Deadline 6 Submission

Written Representation Regarding Written Representations Received at Deadline 5

On behalf of Marlesford Parish Council

Regarding NNB Generation Company (SZC) Limited DCO Application

Plan of the surface water flood risk for properties on Abbey Road, Leiston

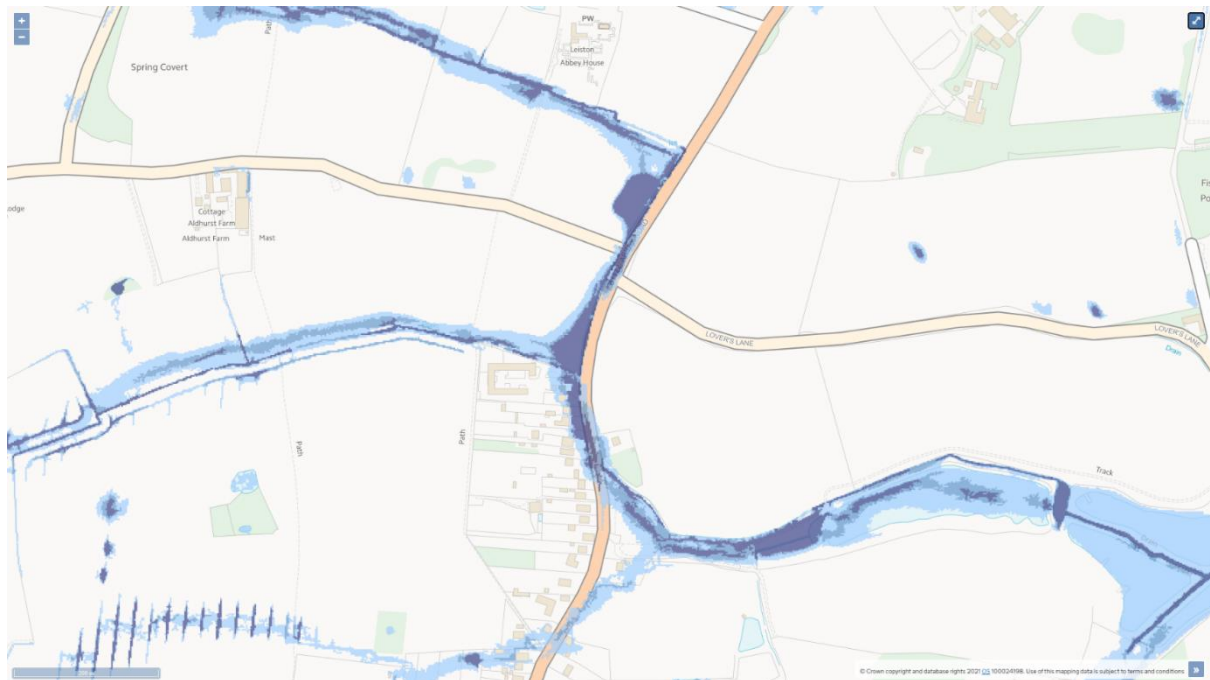
| 8. | SCC | <p>Potential for increased surface water flood risk at several sites.</p> <p>The Applicant has said "No new data will be available during the examination for the park and ride sites, freight management facility and green rail route. On the basis of existing data, SZC Co. is confident that SuDS-led design strategies can be delivered within the Order Limits for these sites."</p> <p>SCC has responded: Whilst productive discussions on Sizewell Link Road, Two Village Bypass and Yoxford Roundabout have taken place, the level of information shared with SCC to date, short of results of infiltration testing, is limited. No comprehensive outline surface water drainage strategy has been presented with supporting calculations, plans and sections, for either of these three schemes. Section highlighted yellow – To confirm, is the Applicant stating they do not intend to provide any further information, to supplement that contained within the Outline Drainage Strategy, for any of the listed sites? If this is the case, SCC have serious concerns regarding this approach. If this is not the case, SCC would welcome the Applicant clarifying what this statement relates to.</p> | <p>We support SCC's position on the supply of detail relating to surface water drainage at the Southern Park and Ride. We believe the Applicant is relying on a SUDs strategy and we have long had concerns that insufficient detail has been supplied on whether such an approach is feasible and workable.</p> <p>We would ask the Applicant to produce better detail on their drainage strategy for the Southern Park and Ride – particularly as it is sited in an elevated position a short distance from and above the A12 northbound carriageway.</p> | [REP5-172] [REP3-044] THE APPLICANT'S COMMENTS ON COUNCILS' LOCAL IMPACT REPORT. Table 20.1 Ref 22c Pg 35 |

Figure 3: Leiston Walking and Cycling Contribution

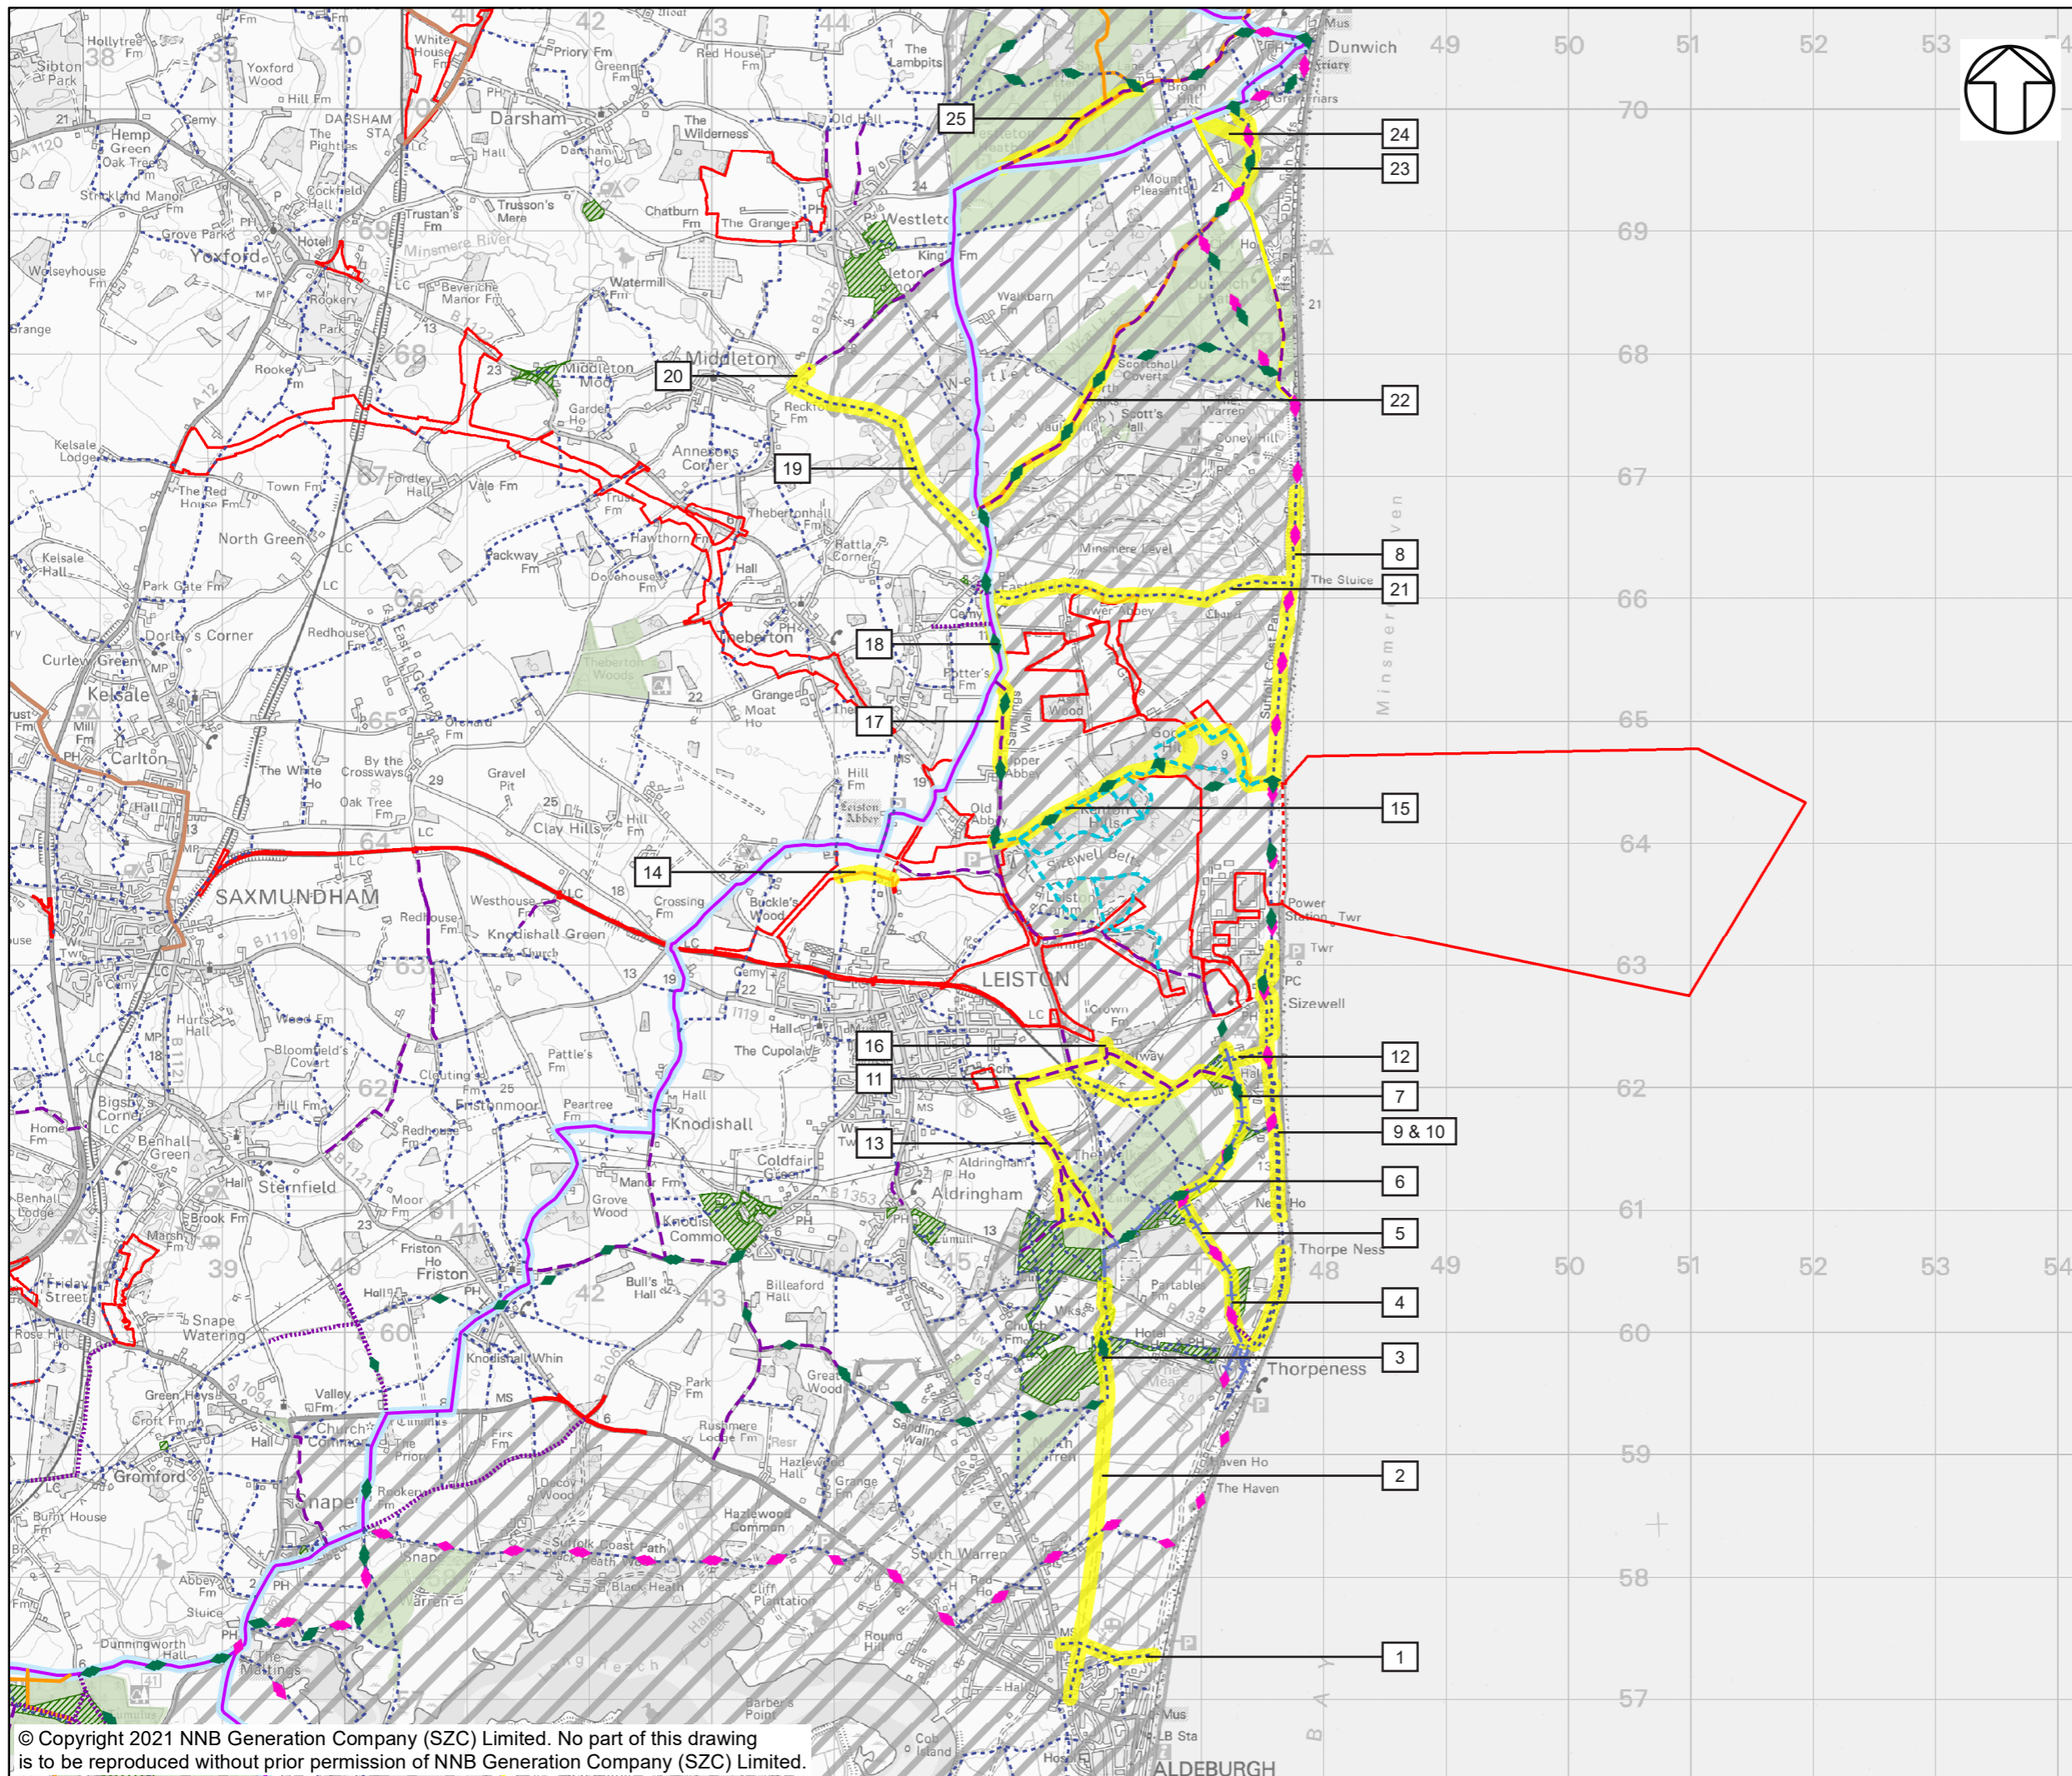
| 10. | SCC | <p>Cycle Connectivity Fund</p> <p>No details regarding the cycle connectivity fund are provided in the draft Deed of Obligation [REP3-027]. SCC has proposed a number of schemes that may have been included in the cycling connectivity fund including</p> <ul style="list-style-type: none"> • Leiston Walking and Cycling Scheme • B1122 Repurposing Scheme <p>Although discussions have been held regarding the possible scope of the cycle improvements to the southern park and ride.</p> | <p>MPC has been arguing for the delivery of an improved pedestrian and cycleway on the northern side of the A12 between Marlesford and the Fiveways Roundabout. This would form an important mitigation measure for pedestrians and cyclists traveling between Marlesford and Wickham Market. From the Applicant’s point of view, delivery of such a facility would provide a legacy benefit to local communities. We urge SCC and the Applicant to work together to ensure that such a scheme comes within the scope of the Cycle Connectivity Fund.</p> | <p>[REP5-172] [REP3-042] THE APPLICANT’S COMMENTS ON WRITTEN REPRESENTATIONS Table 7. SCC’s response to comments from Chapter 16 –</p> |
